CROSSROADS NORTH

EARLY GRADING & EROSION CONTROL PLANS

EARLY GRADING & EROSION CONTROL PLAN

SHEET 2 OF 9 **GR02**

SHEET 3 OF 9

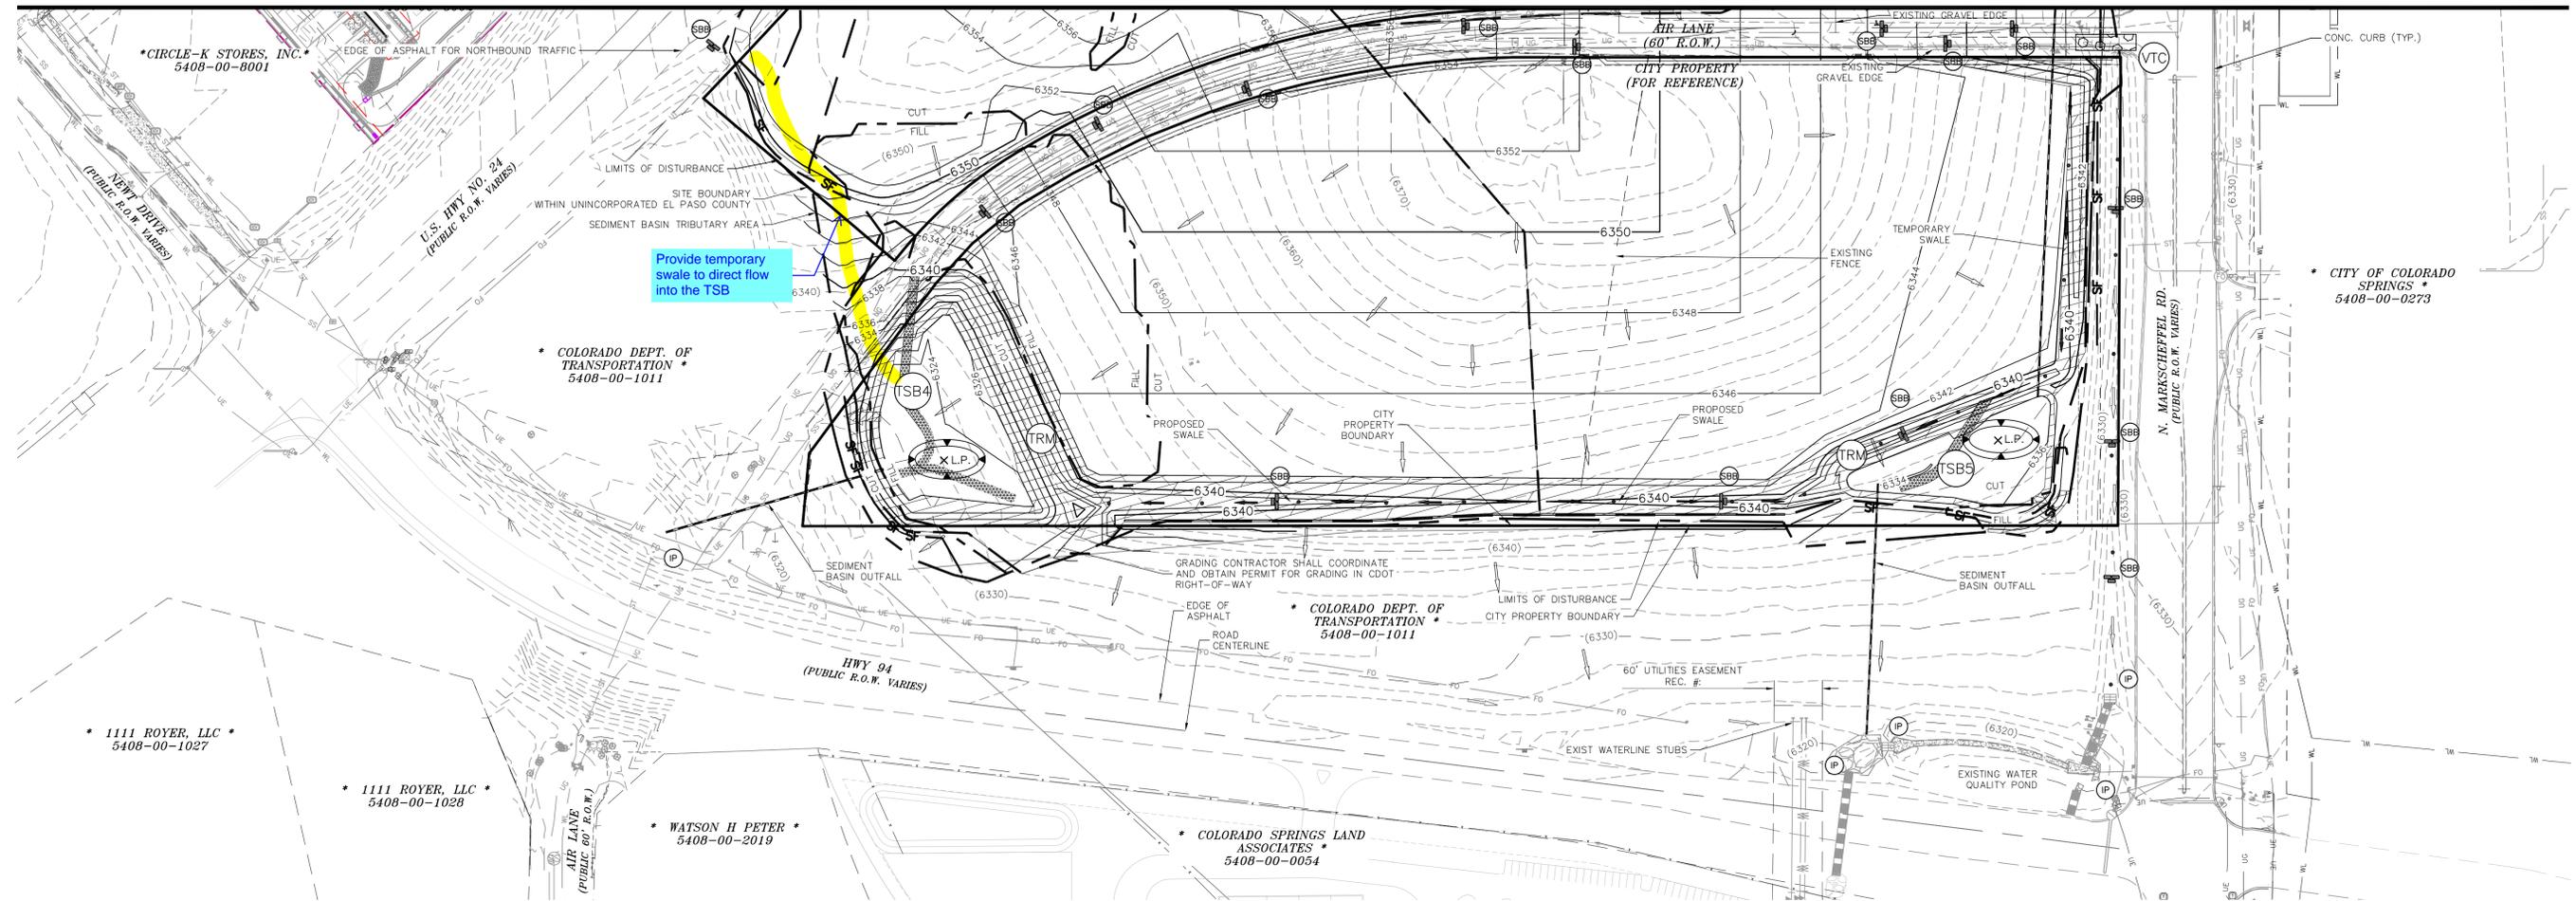
Why is the project adding additional berm along the east side of the ditch?
Provide additional information regarding the proposed berm, preferably as a typical cross section. Identify the side slope, max height, crest width.

Note: Coordinate with CDOT to obtain approval and necessary permit for offsite work within CDOT ROW.

See comment on the TIS. Markscheffel Rd is anticipated to be 6 lanes as such ROW dedication appears to be required.

Provide typical cross section detail of the retaining wall. Cross section to encompass the proposed swale, retaining wall, roadside ditch.
- Identify the swale lining used.
- Add a note that building permit is required since the retaining wall is greater than 4'
- Label the specific retaining wall product/system proposed. Make sure the retaining wall offset from the ROW is sufficient so the retaining wall does not extend into the ROW.
- Identify the max height of the retaining wall.

Identify size and material used for the temporary culvert. Typical for all pipes installed with the early grading

Add the hatching on the legend. Identify the material used.
COMMENT ADDRESSED. ACCESS ROAD WILL BE ADDRESSED WITH POND DETAILS.

Provide typical cross section. The east side appears to be an embankment. The should be a minimum width of 12 ft at the top of the embankment structure per DCM 11.3.3.
COMMENT ADDRESSED. MINIMUM WIDTH 12'.

Revise pipe layout to provide a smooth low head loss transfer of flow.
COMMENT ADDRESSED. PIPE LAYOUT REVISED.

COMMENT ADDRESSED. TO MAINTAIN OFFSITE FLOWS AS OFFSITE. ADDITIONAL CALLOUTS ADDED. WE HAVE COORDINATED WITH CDOT.

provide typical cross section
COMMENT ADDRESSED. CROSS SECTION PROVIDED.

COMMENT ADDRESSED. ISSUE RESOLVED WITH THE CITY OF CS.

Include the hydraulic calculation for the channels in the EGP Final Drainage Report.
COMMENTS ADDRESSED. CROSS SECTION PROVIDED. SWALE LINING IDENTIFIED. WALLS ARE 4' OR LESS. WALL PRODUCT AND SYSTEM IDENTIFIED. WALL HEIGHTS CALLED OUT. HYDRAULIC CALCULATION TO BE PROVIDED IN FDR.

COMMENT ADDRESSED. CULVERTS SIZE AN MATERIAL CALLED OUT TYPICAL.
